Our Case Number: ABP-316828-23

Re: Tallaght/Clondalkin to City Centre BusConnect Core Bus Corridor Scheme.
Tallaght/Clondalkin to Dublin City.

- Reference the proposed introduction of a two lane Bus link bus route and cycle lanes, off the Greenhills Road and through the residential developments in the cul de sac at Birchview Avenue, in front of the existing two storey houses and behind the single storey houses at Parkview, ref General Arrangements sheets numbers 10 of 56 and 11 of 56

Programme Title BUSCONNECTS DUBLIN CORE BUS CORRIDORS INFRASTRUCTURE WORKS			
Drawing Title TALLAGHT/CLONDALKIN TO CITY CENTRE CORE BUS CORRIDOR SCHEME STREET LIGHTING			
Drawing File Name BCIDA-ACM-LHT_RL-0809_XX_00-DR-EO-0010	Sheet Number 10 of 56	Status A	Rev M01

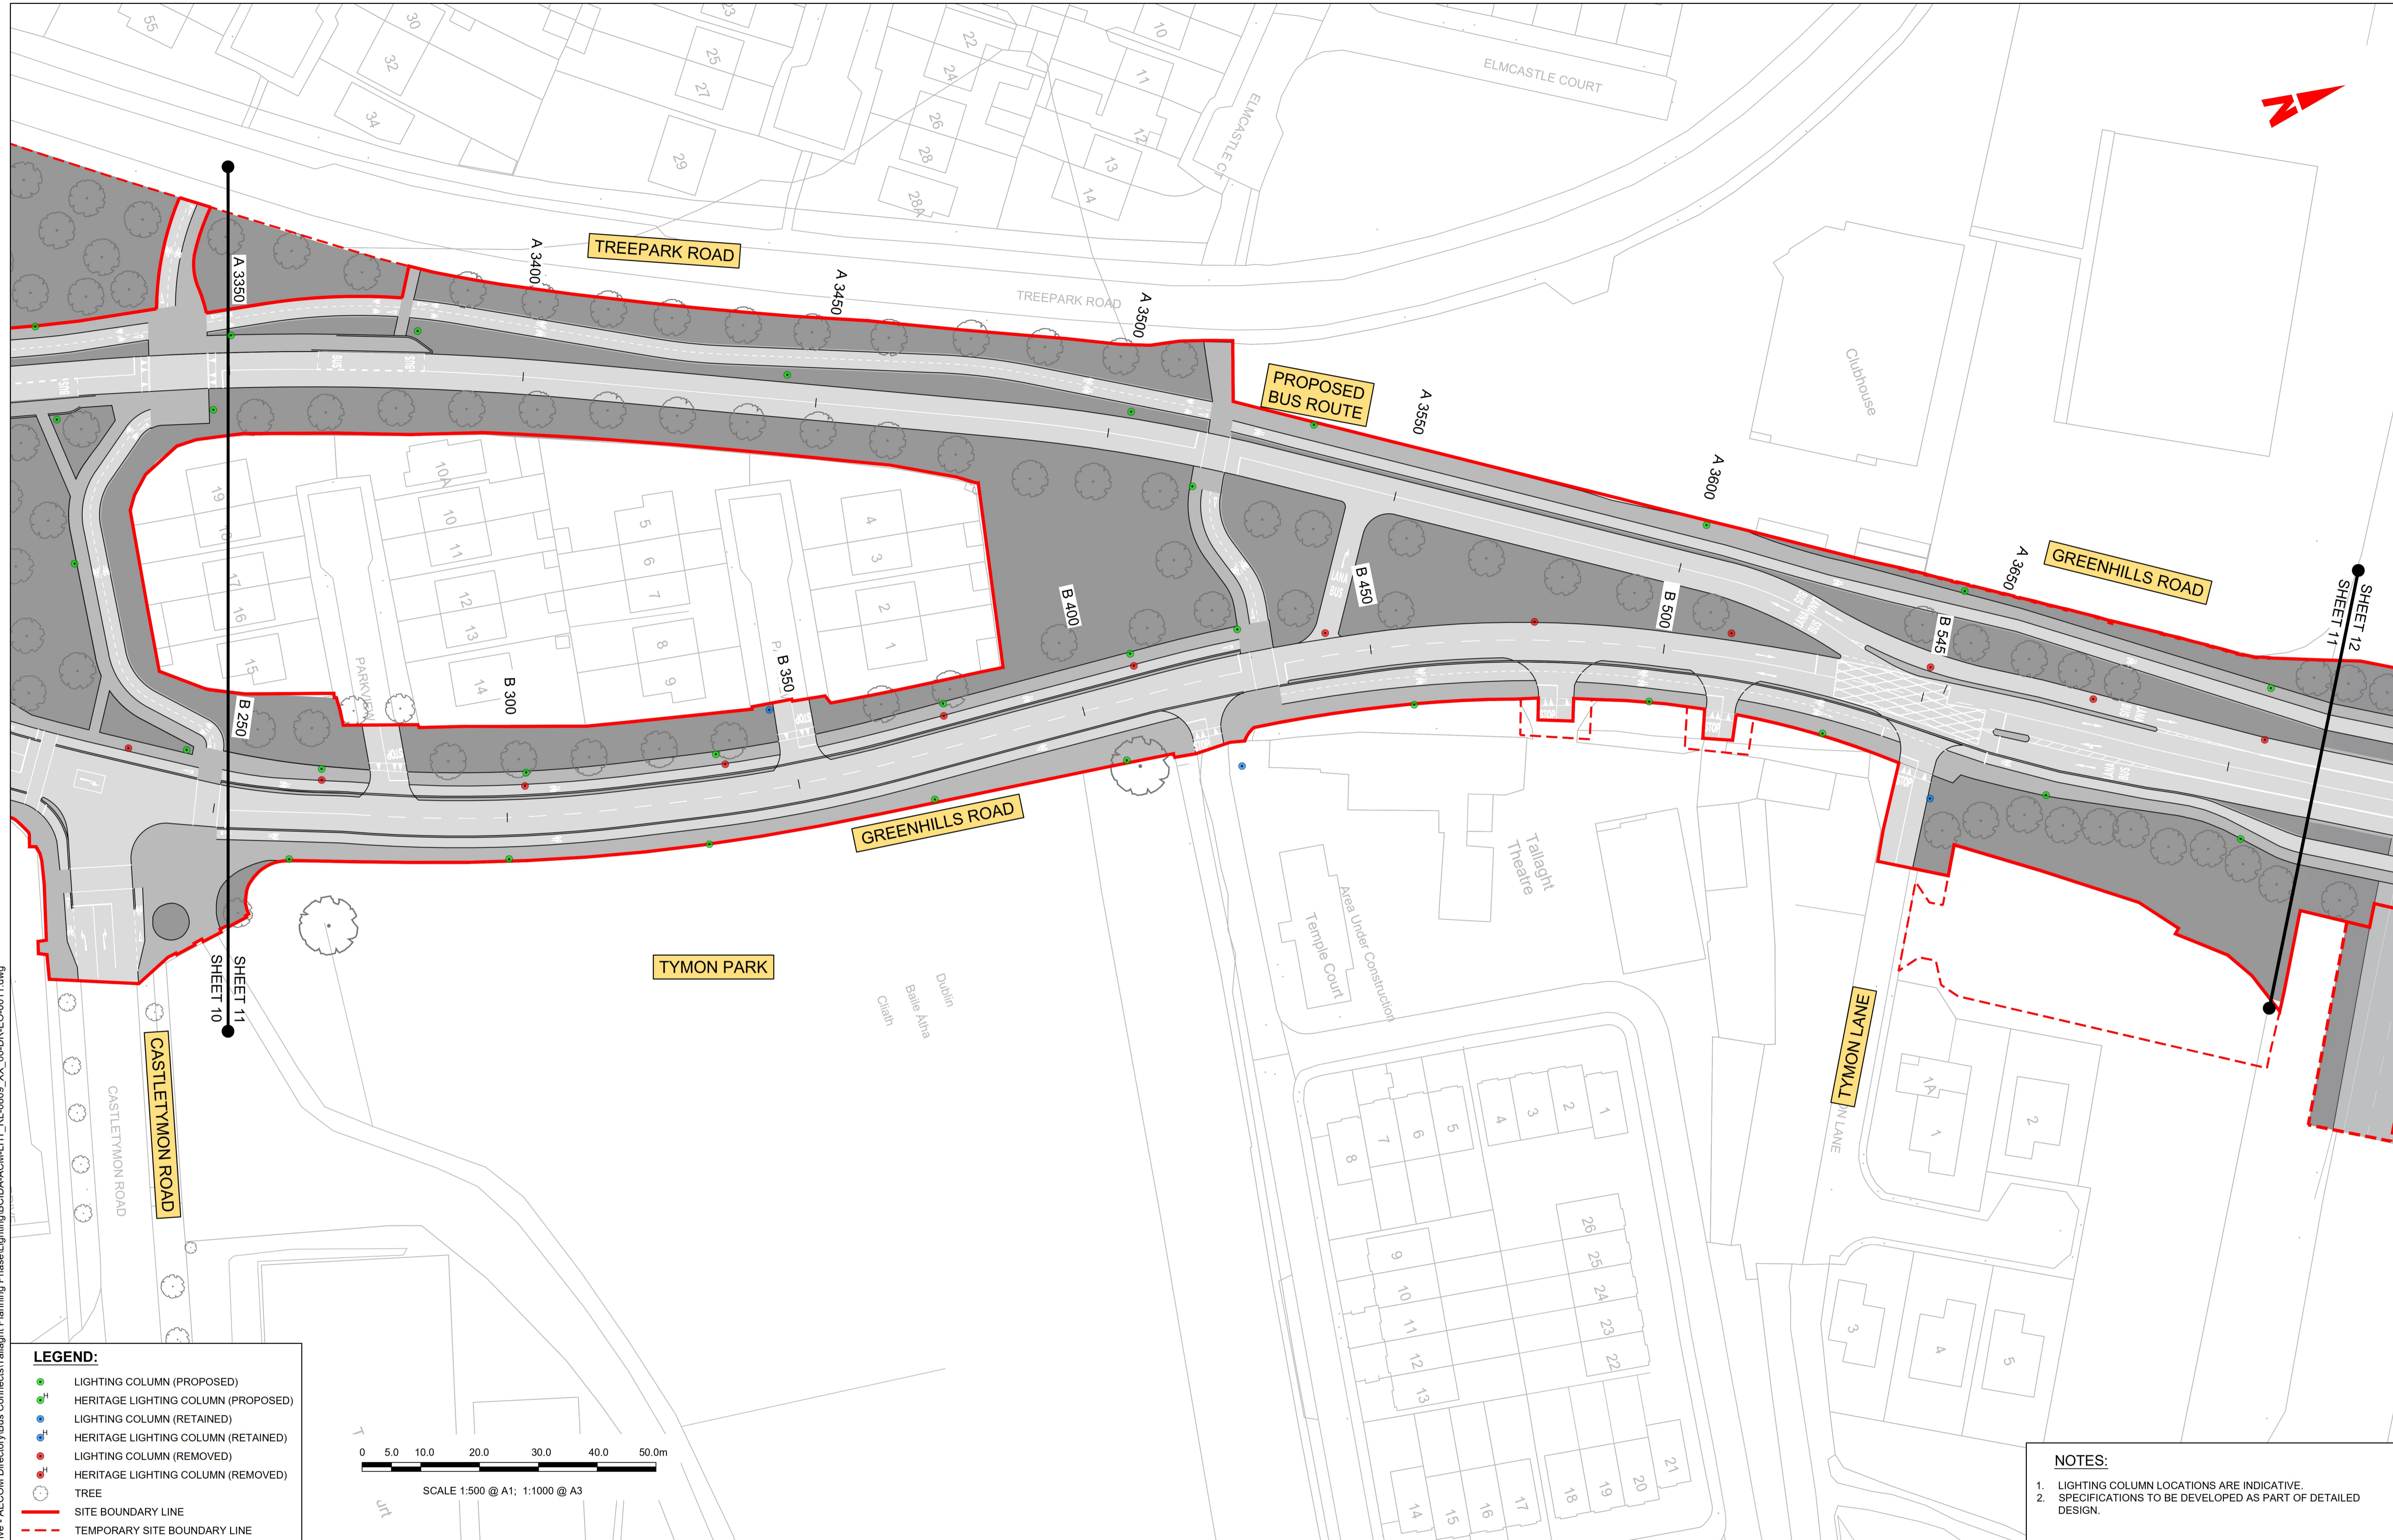
- The homes situated on Birchview Avenue are set back and separated from the heavy traffic of the Greenhills Road by their green open space. This proposal will bring Double Decker vehicles (buses) and bikes to the immediate front and sides of their homes, introducing an element of danger to their young children and grandchildren it will increase noise levels and potentially increase the risk of pollution by the introduction of buses into this quiet residential area. The removal of the Green Open Space will have a negative impact on the Community health and wellbeing, by removing a passive recreation area, removing a safe space for children and an exercise and safe walking area for senior citizens. The single storey houses in Parkview are set out in small cul de sacs, populated mainly by very young families and senior citizens. They are in the main accustomed to traffic passing their homes to the front and sides of their houses, along the Greenhills Road. This proposal will bring heavy traffic to the rear of their homes, particularly past their bedroom windows and introducing a new level of noise at the rear of their homes, while still being effected by passing traffic on the Greenhills Road. A double whammy of noise pollution!

- The plan proposes to remove three existing bus stops on the Greenhills Road and relocate them on the new bus lane. This again will impact on students from Collaiste De Hide and Scoil Iosa who can safely access the current 27 bus stops at Tymonville (2340) and beside the Cuckoo's Nest (2339) and if the plans are approved, will now have to cross three roads to access the new proposed bus stops. This will also have an impact on people with mobility difficulties, who currently use the existing bus stops but will have to walk a much longer distance to get to the relocated stops, which in my humble opinion, defeats the purpose of accessibility and sustainability for those citizens.
